From: [REDACTED]
Sent: 17 December 2019 14:30
To: A38 Derby Junctions <A38DerbyJunctions@planninginspectorate.gov.uk>
Subject: RE: TR010022 - A38 Derby Junctions highway improvement scheme

QUESTIONS TO HIGHWAYS AGENCY ABOUT THEIR A38TRUNK PROPOSALS

**KINGSWAY JUNCTION  
PROPOSED CONSTRUCTION  
SEQUENCE  
PHASE 1**

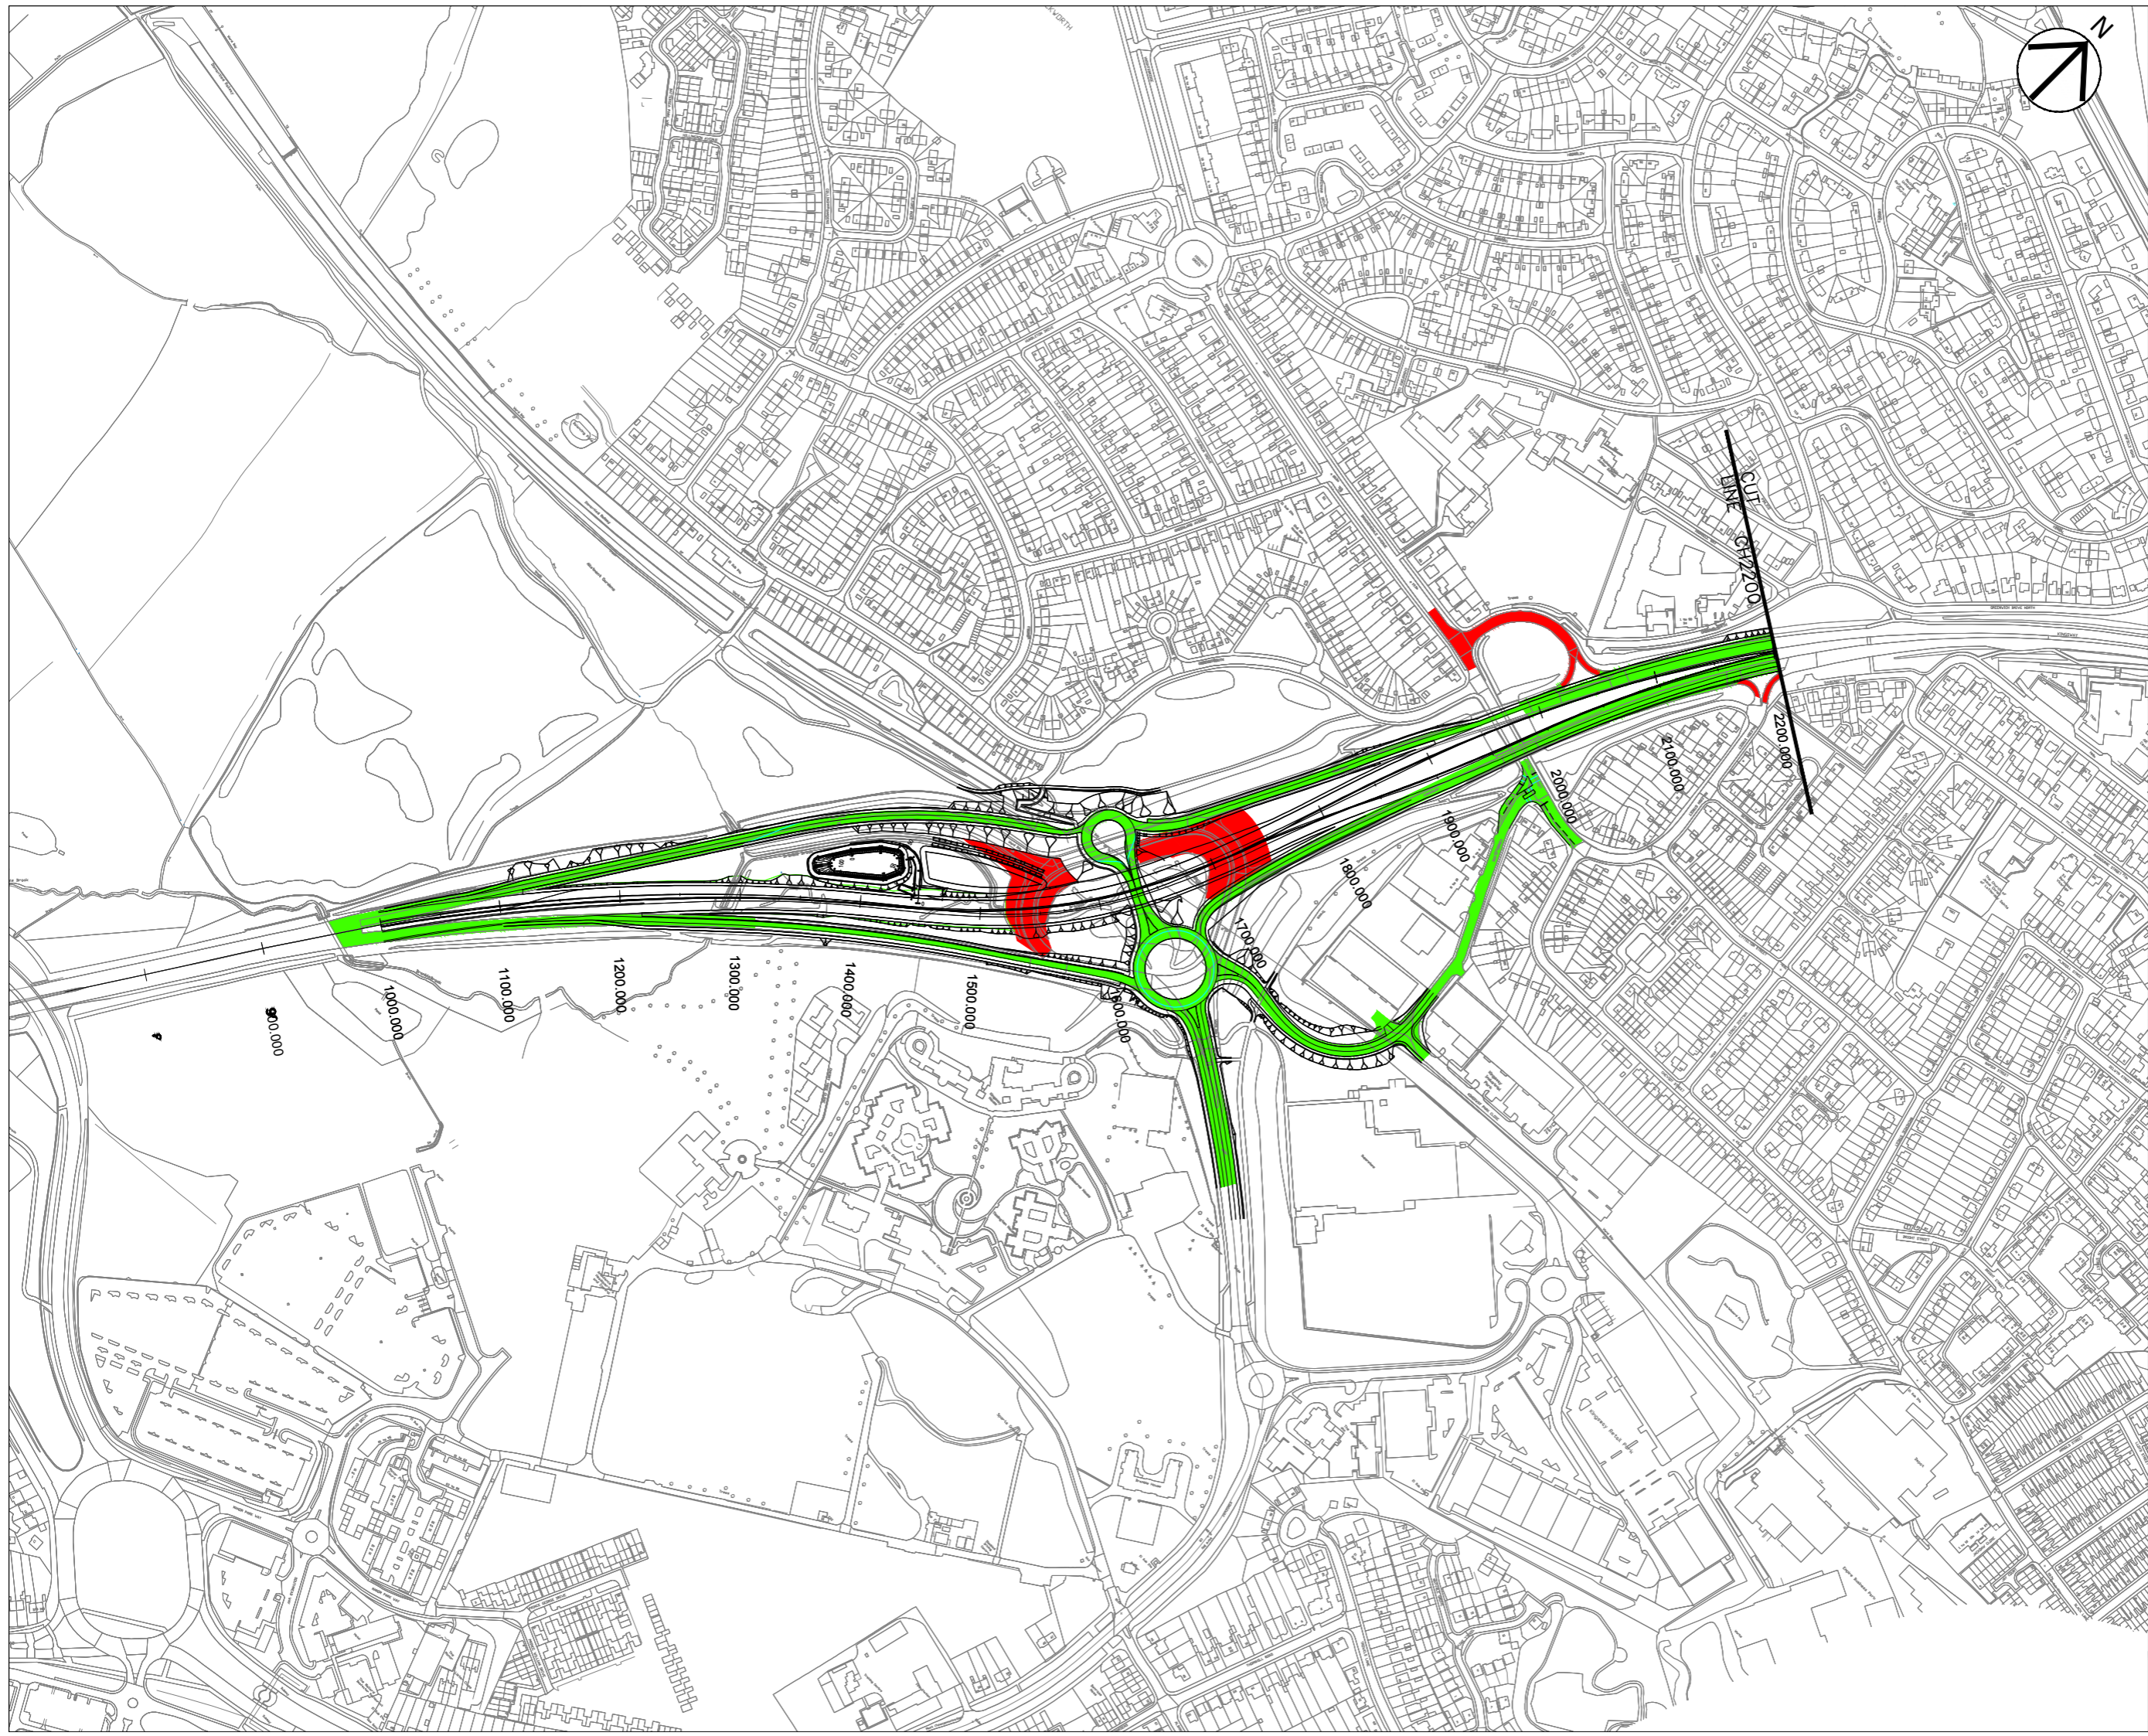
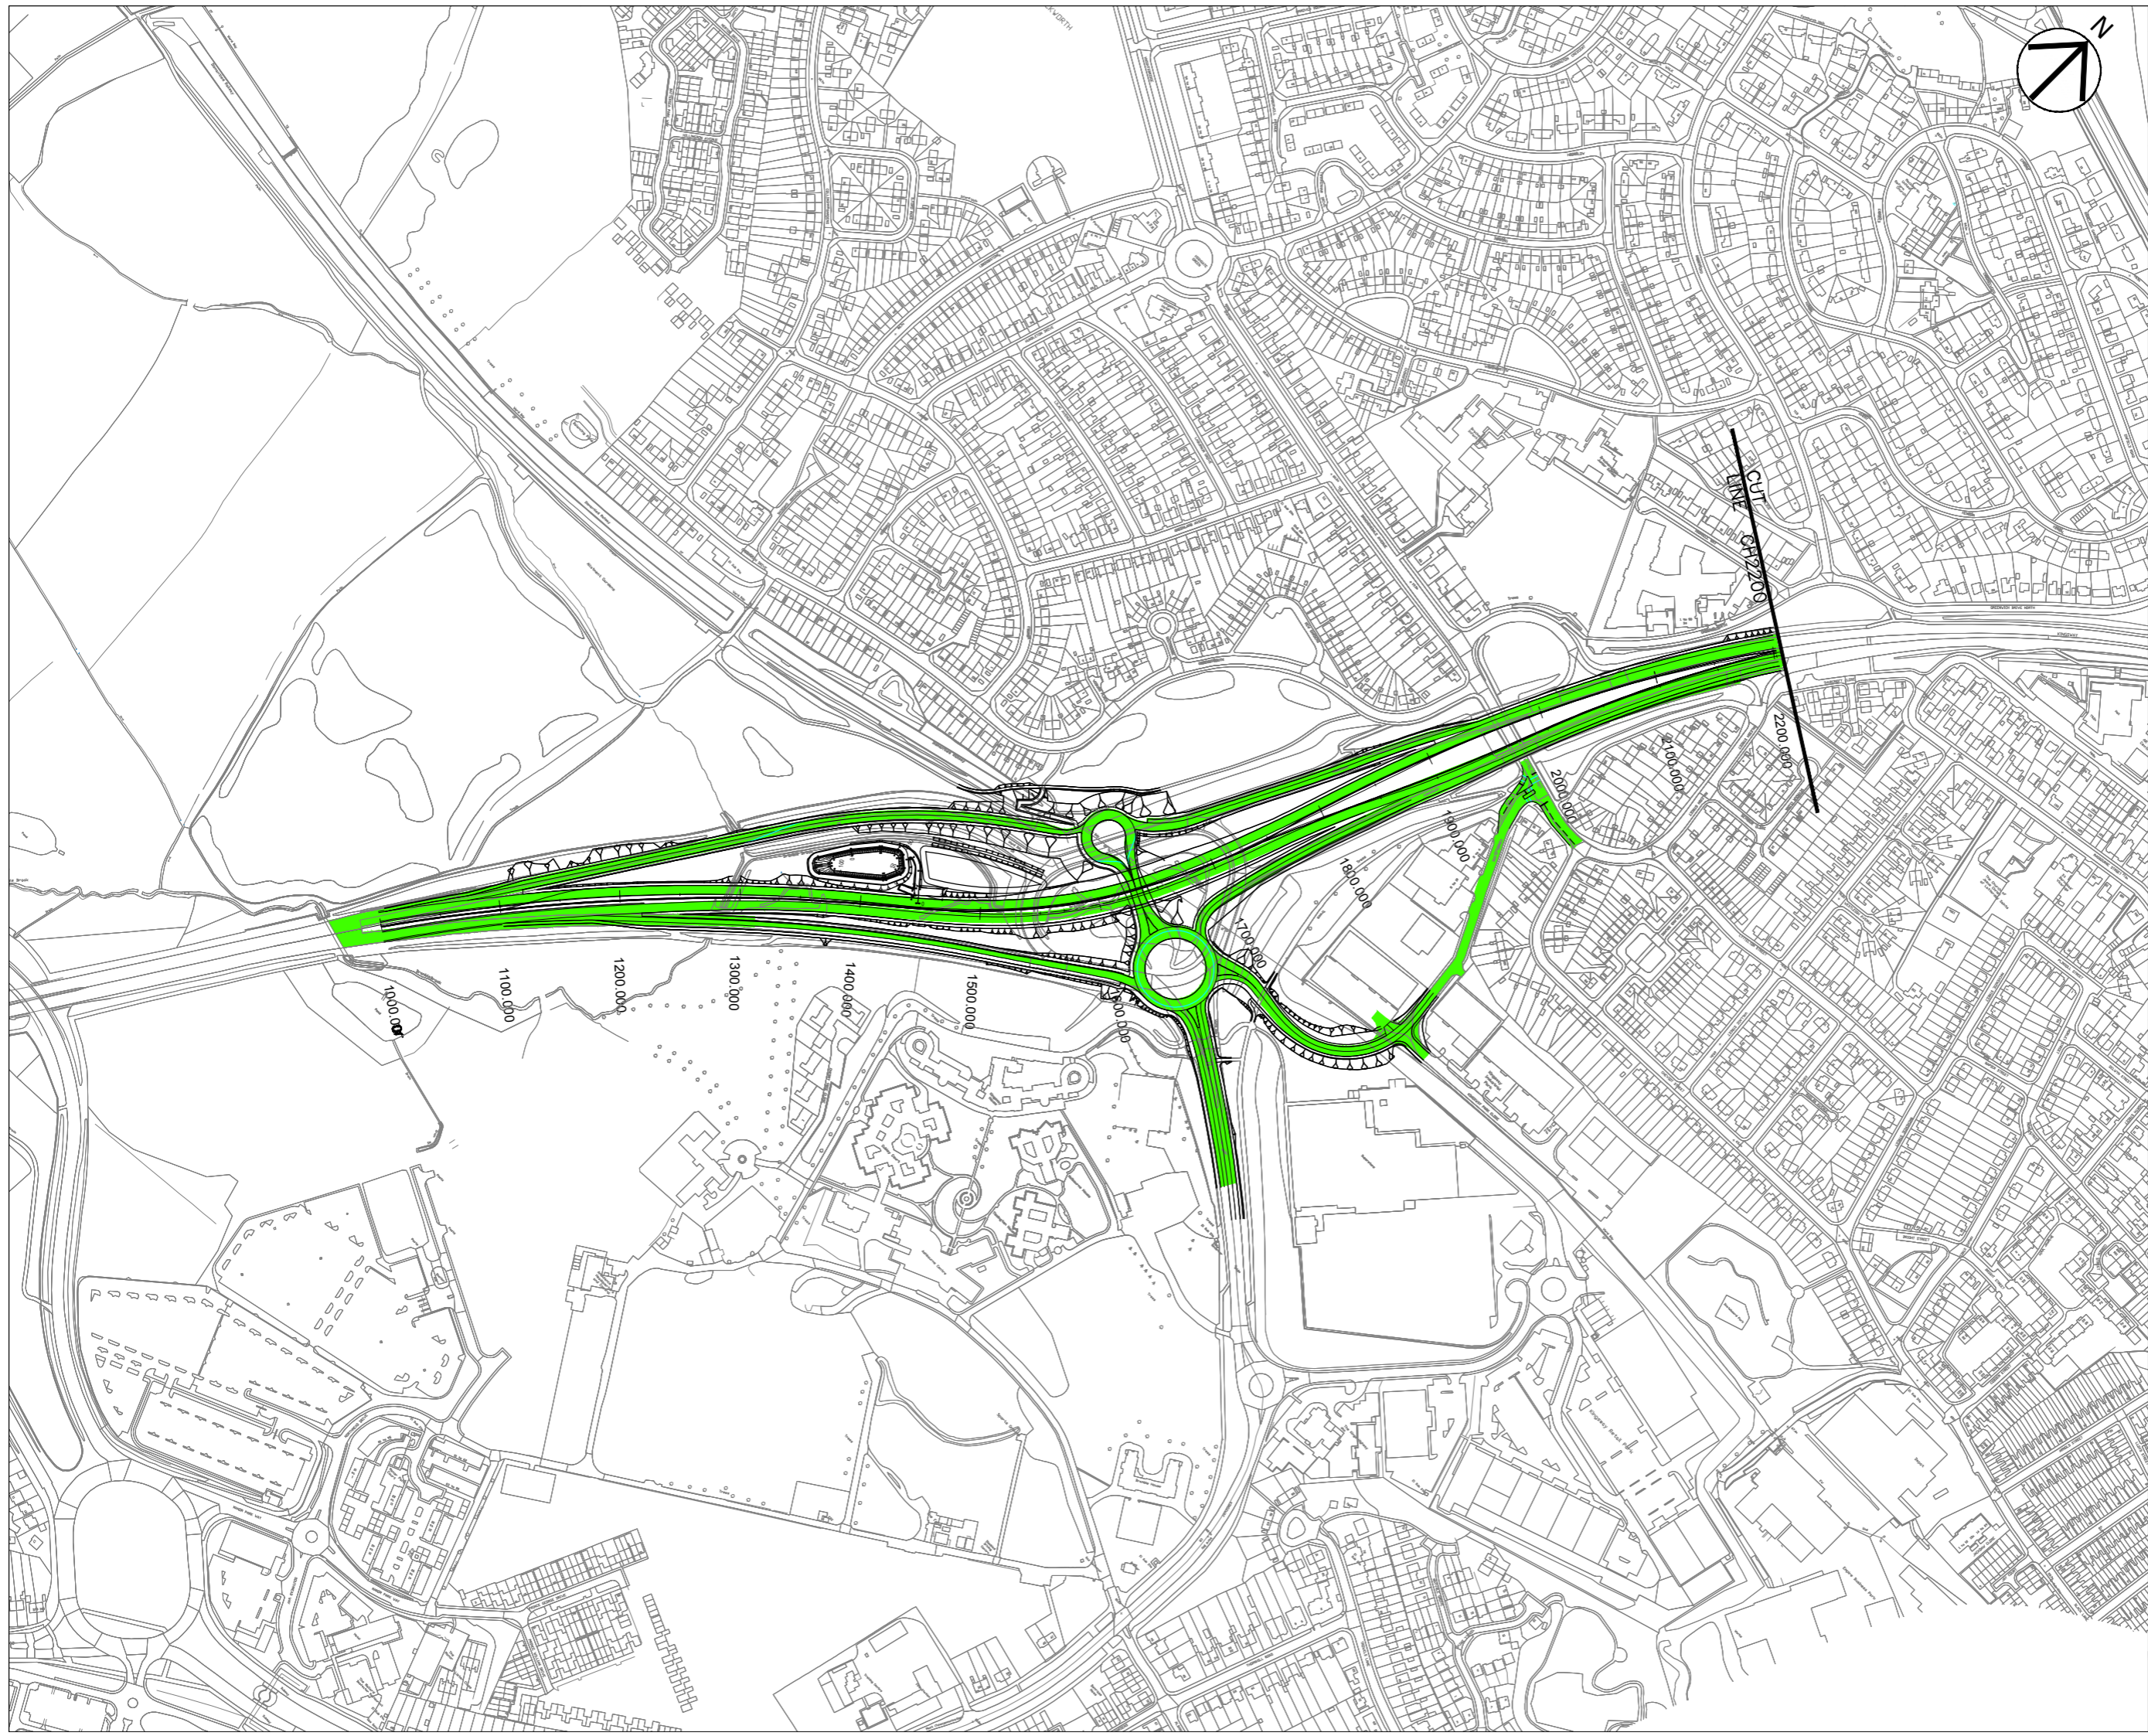
2 How will the HA construct 8 new bridges, new carriageways and new roundabouts ON THE LINE OF THE EXISTING ROAD without leading to massive delays for the 10,000+ vehicles a day on the A38T and for Derby urban traffic for 3 years ? The last attempt by HA in 2015 of “Interim Improvements” at Markeaton and Little Eaton, involving only fitting traffic lights and an extra carriageway at these roundabouts, led to enormous chaos and delays DAILY for 6 months. How will HA keep the traffic moving ? Will it be diverted down A6 Duffield Road and Broadway, where there are 3 schools ?

3 Why are there 7 Junctions of the A38T with Derby? All are not needed, especially Kingsway junction and Kedleston Road Junction, especially if the proposal in 2) above is implemented. Kingsway junction can be eliminated if the Uttoxeter Road Junction is made bi-directional with a new bridge, making this the major south-Derby junction leading along this dual carriageway into town . This work can be carried out OFF-ROAD..
